Application number: 2020/93863	
What is the application for?:	Erection of pigeon shed
Address of the site or building:	Land off, Deer Hill End Road, Meltham, Holmfirth, HD9 5PT
Postcode:

ELEVATION A

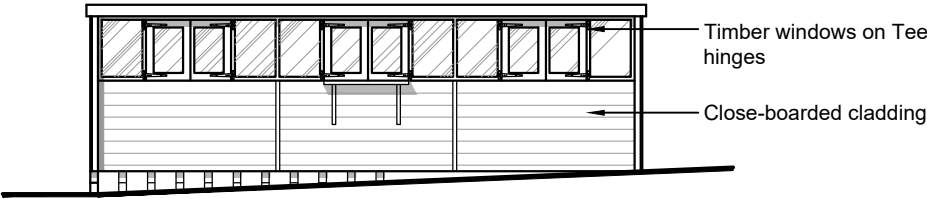
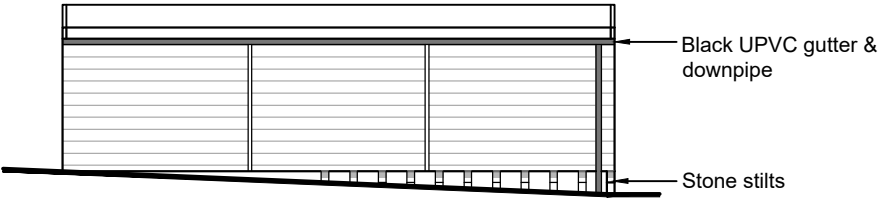
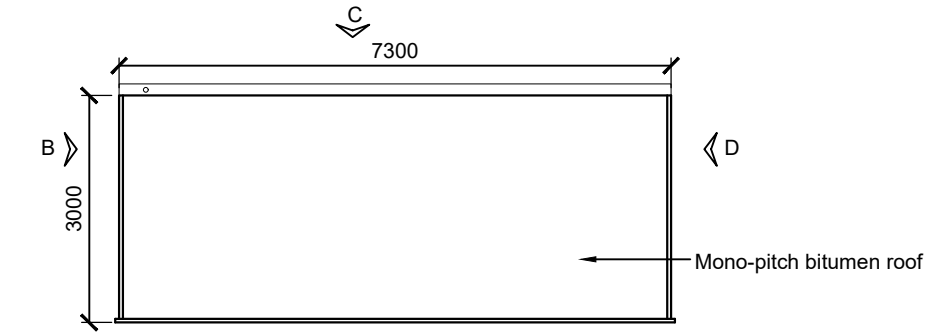
Type of comment: An objection
Green belt land The people are living in the field and making a mess of the general neighbourhood which surrounds it. The design stands out and ruins the looks of the area
